Town & Country Planning Act 1990 (as amended)
Town & country Planning (Development Management Procedure) (England) Order 2015

Rear and side, single and two storey extension incorporating rear balcony. This application affects the Character & Appearance of the Aldwick Bay Conservation Area
3 The Orchard Aldwick

PROPOSED ELEVATIONS

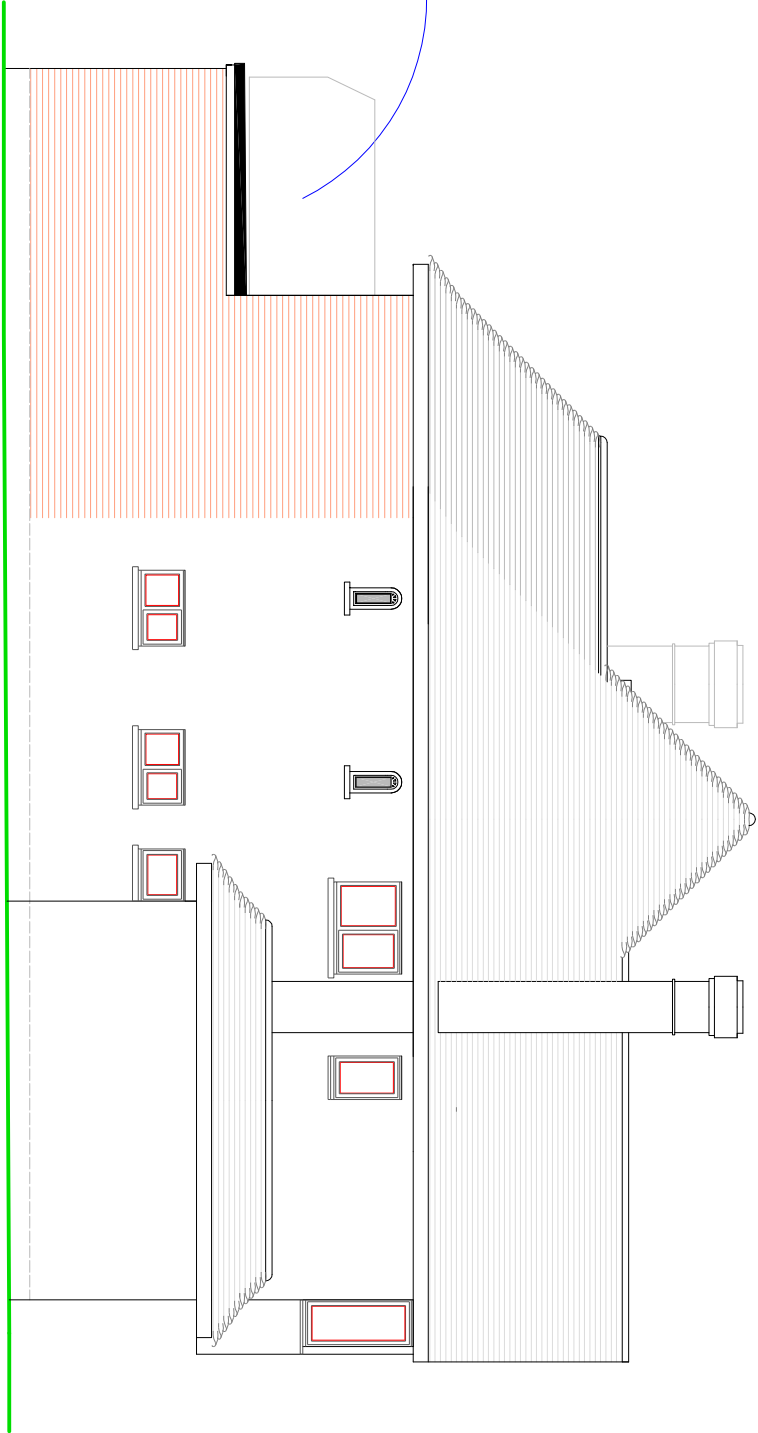
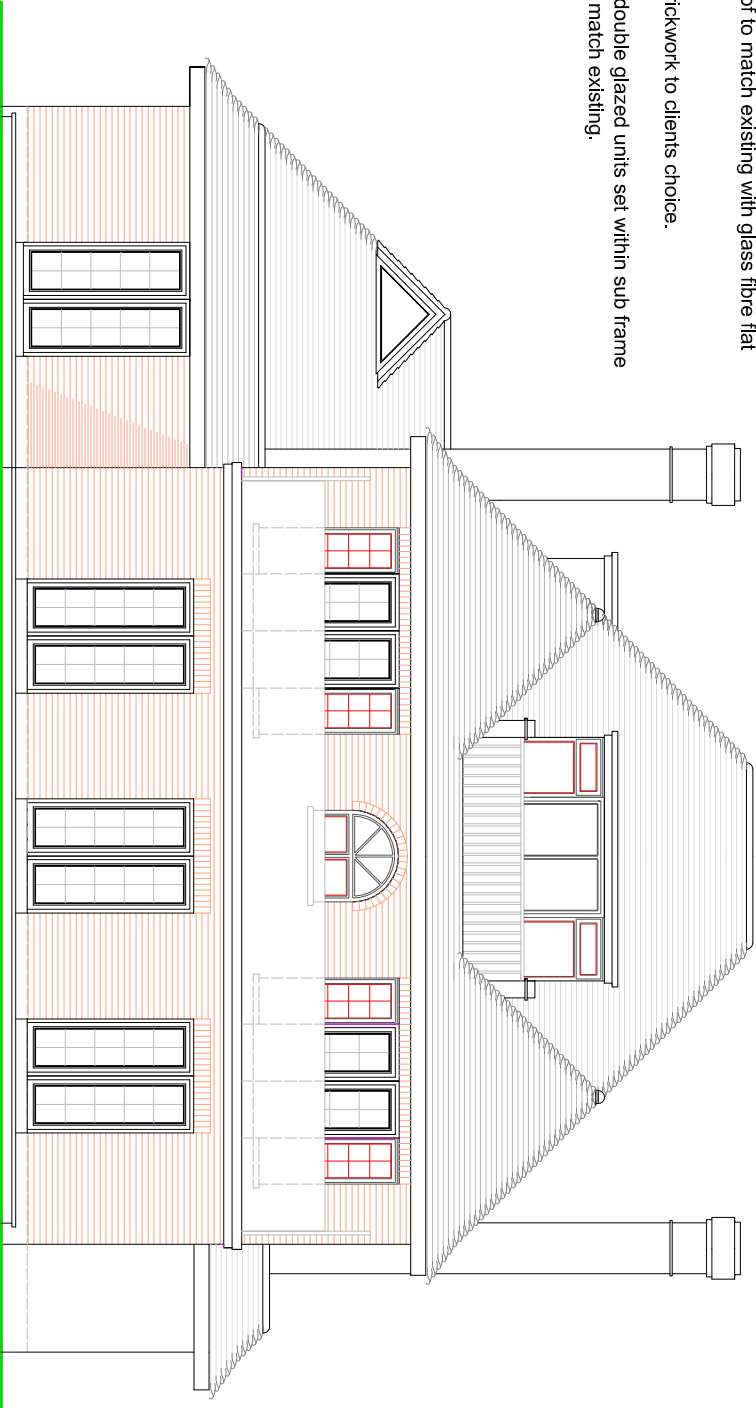
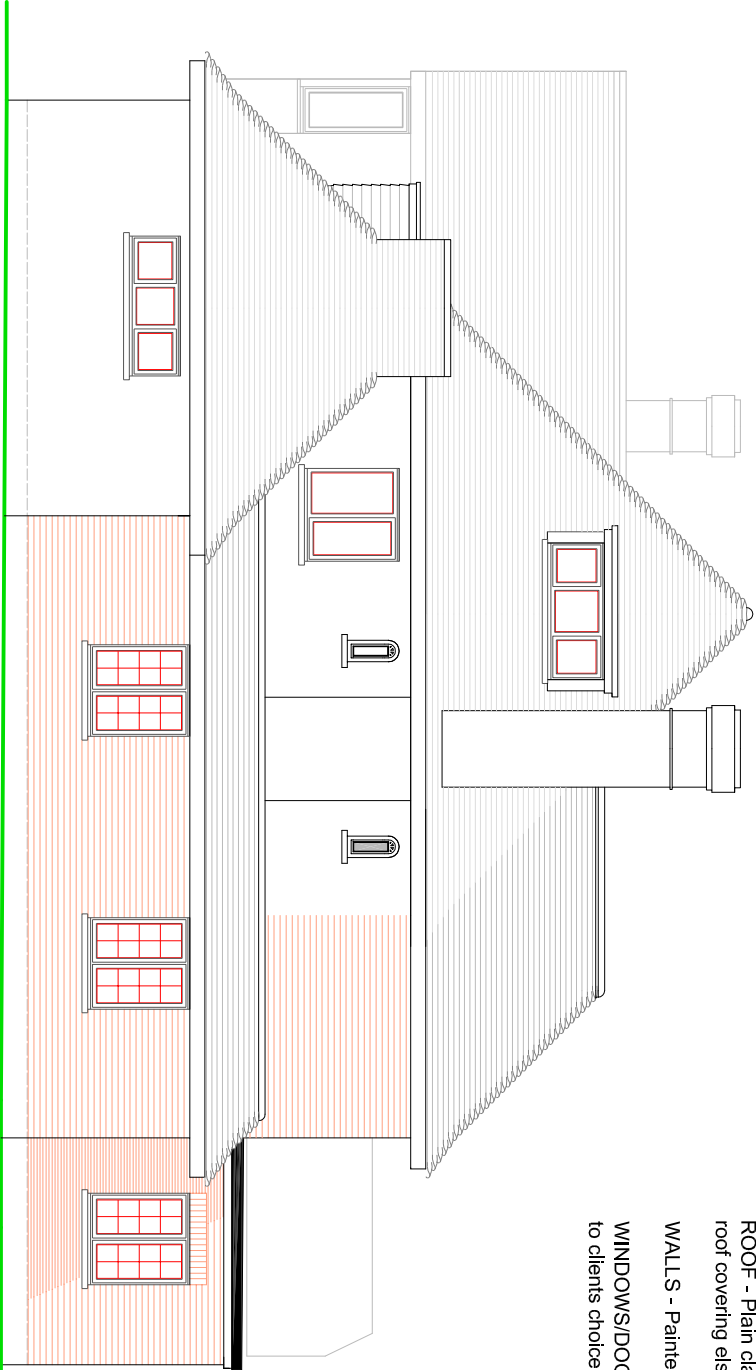
Further to my last I have again spoken at length to the applicants, who I'm informed by have also been in contact with yourselves. I am now told that after consultation they are sourcing a glass alternative to at least part of the balcony which will obscure the view both in and out, this will hopefully be agreeable to all parties and alleviate the problem. I have asked them to keep me informed and importantly what the conservation officers comments are on the glass option. I cannot fully comment on our situation until such time as the material has been sourced, to know the impact on the the street view, if any. I have also been informed by the applicants that they have had lengthy conversations with their other neighbour both prior to their holiday and this week and am told they have no objections to the work. I cannot see apart from the side elevation being extended how the street view would be changed dramatically as they only element on view would be an extension of the same and the possible addition to the end element on the balcony. Further to this the plans look sympathetic to the current style of the house. I will await further updates prior to making our final decision. Brian Stanley Planning Director.
